**WEST SUSSEX COUNTY COUNCIL
PLANNING SERVICES CONSULTATION**

SUBJECT: A/171/17/DOC - Application for approval of details reserved by condition imposed under planning permission A/184/15/PL relating to conditions 3-visibility splays, 4-details of screen walls and/or fences, 5-surface water drainage, 9-level survey, 10-landscape scheme, 11-schedule of materials & finishes & 13- location of swallows nests.

Herons Farm, Dappers Lane, Angmering, West Sussex, BN16 4EN

Proposed Cottages & Stables
 Herons Farm, Dappers Lane,
 Angmering
 Scale 1:200
 Drng no 459/08

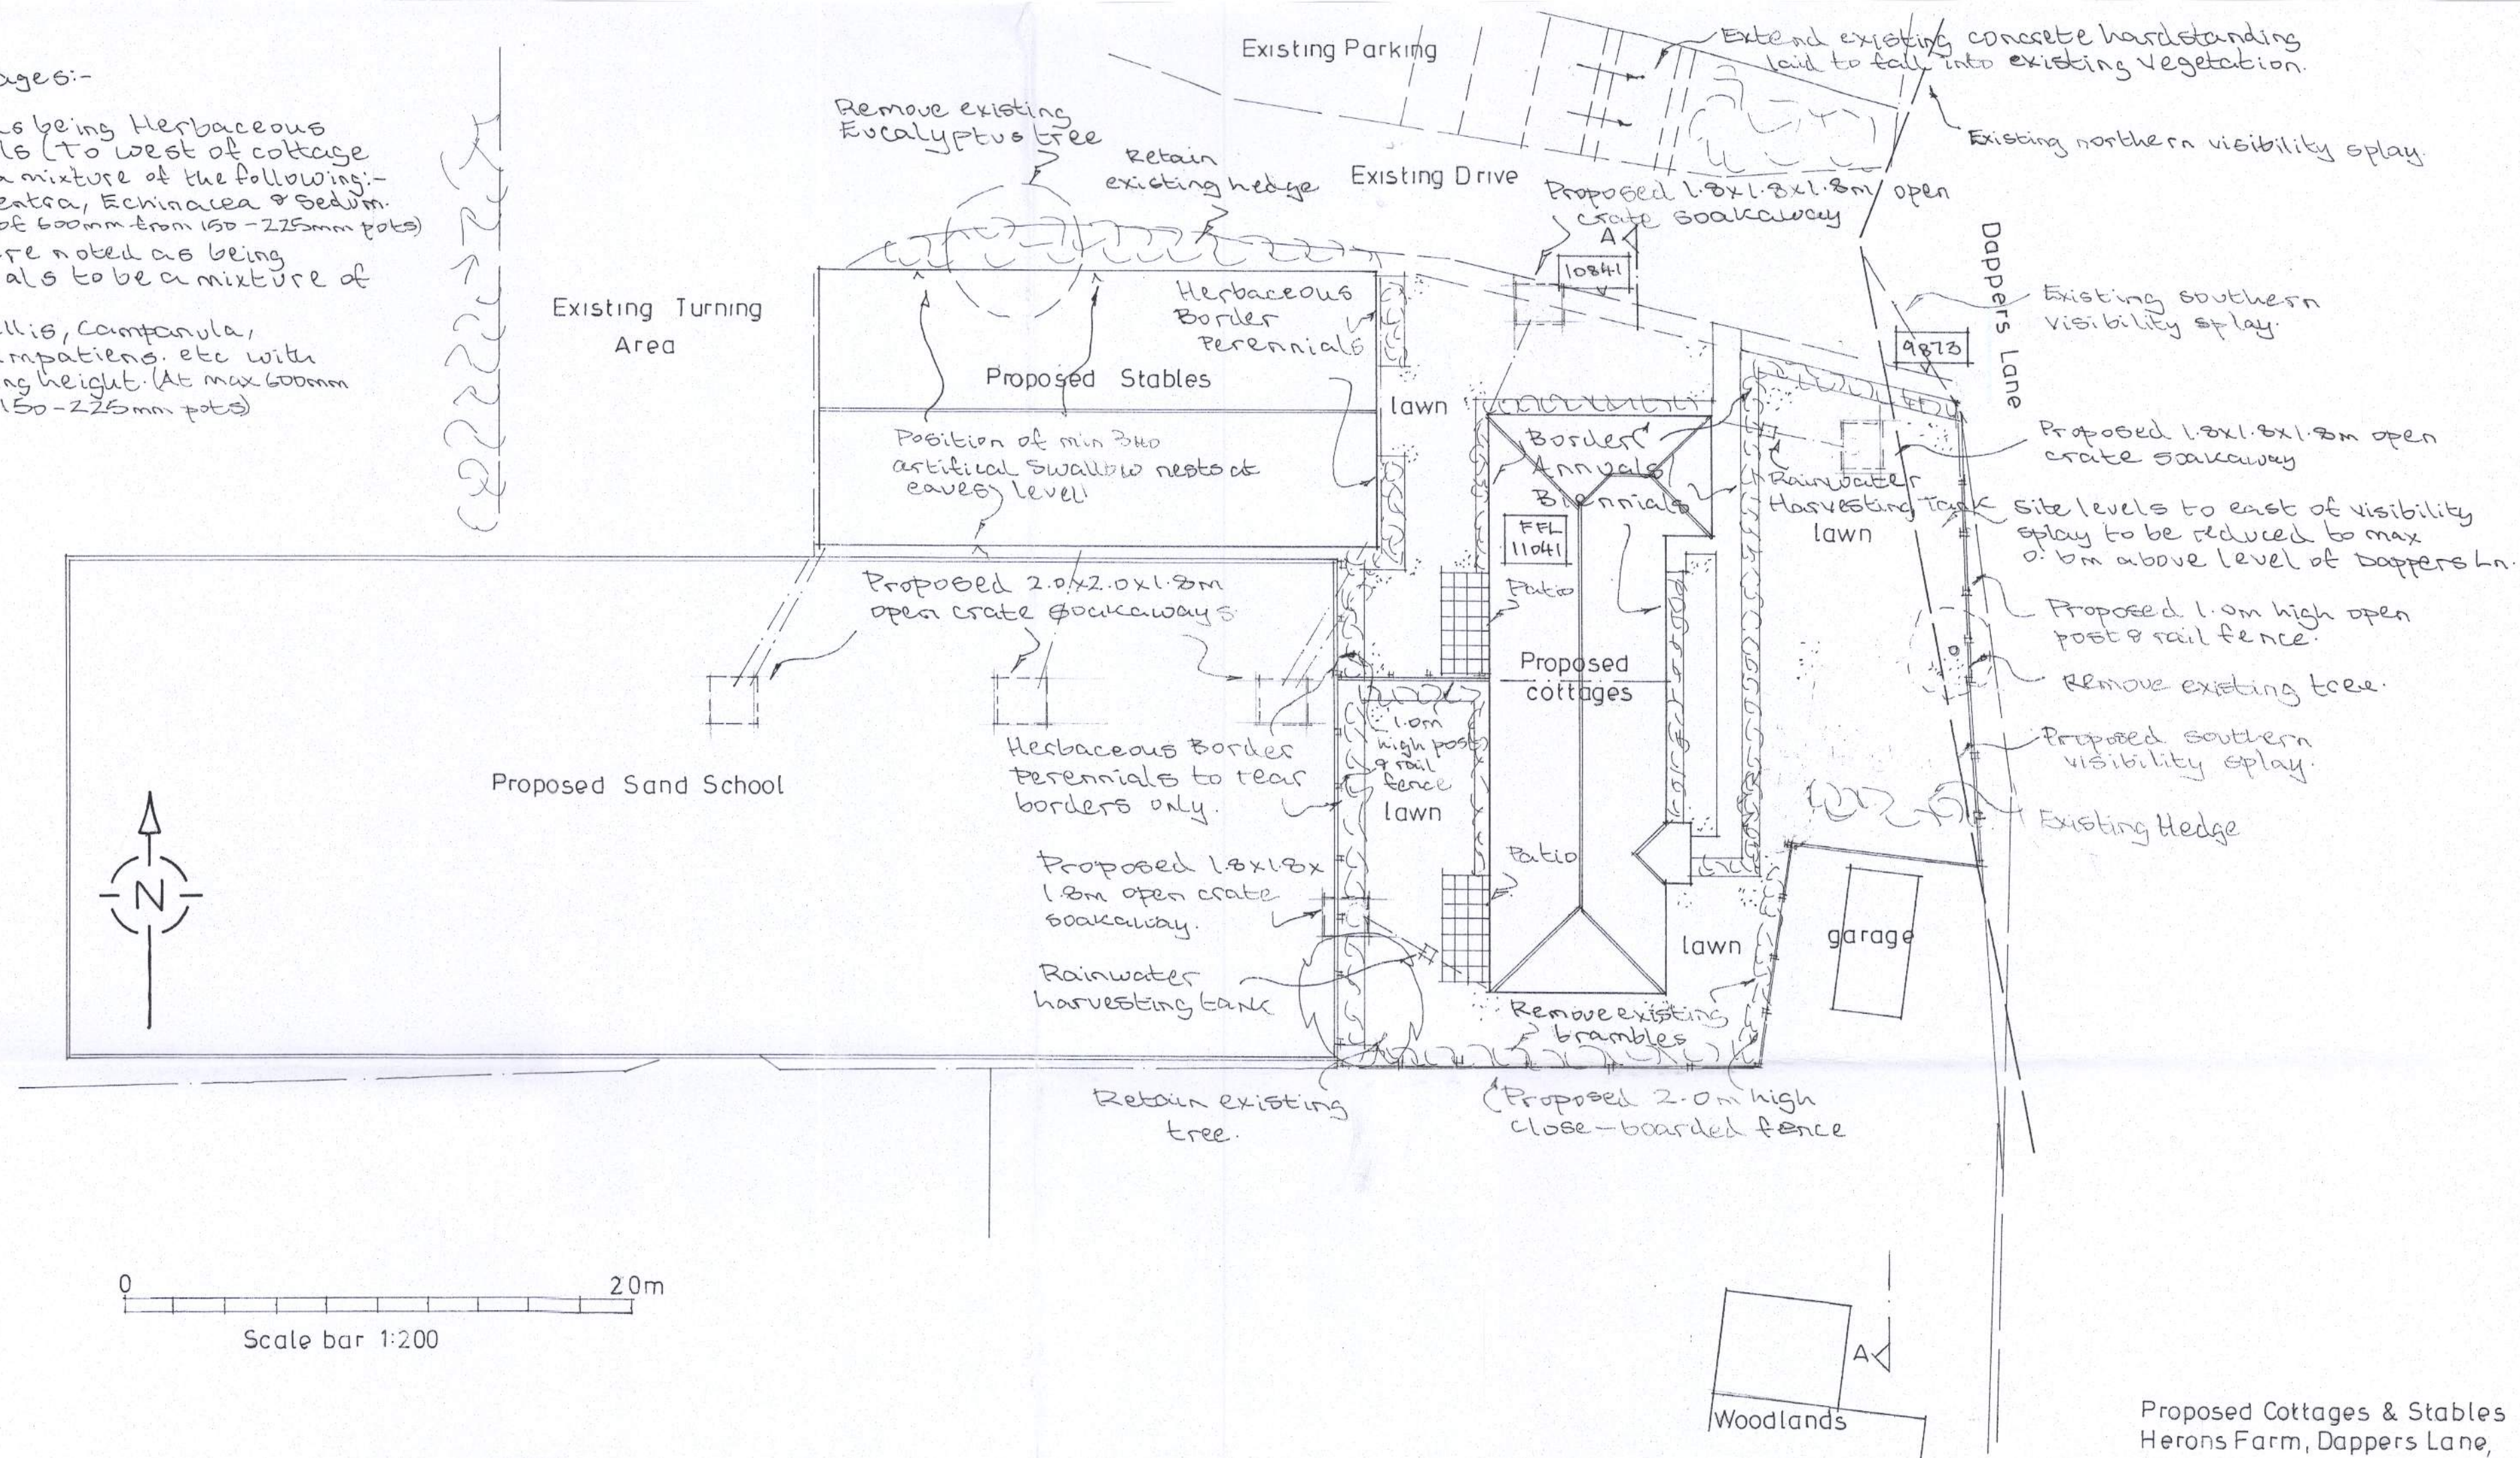
Condition 3 relates to improved visibility at the existing access for the approved development. The LHA would raise no concerns to the proposed splays demonstrated on drawing no:459/08A, this drawing shows and increase in visibility to the south from approximately 8m to 26m. No objection.
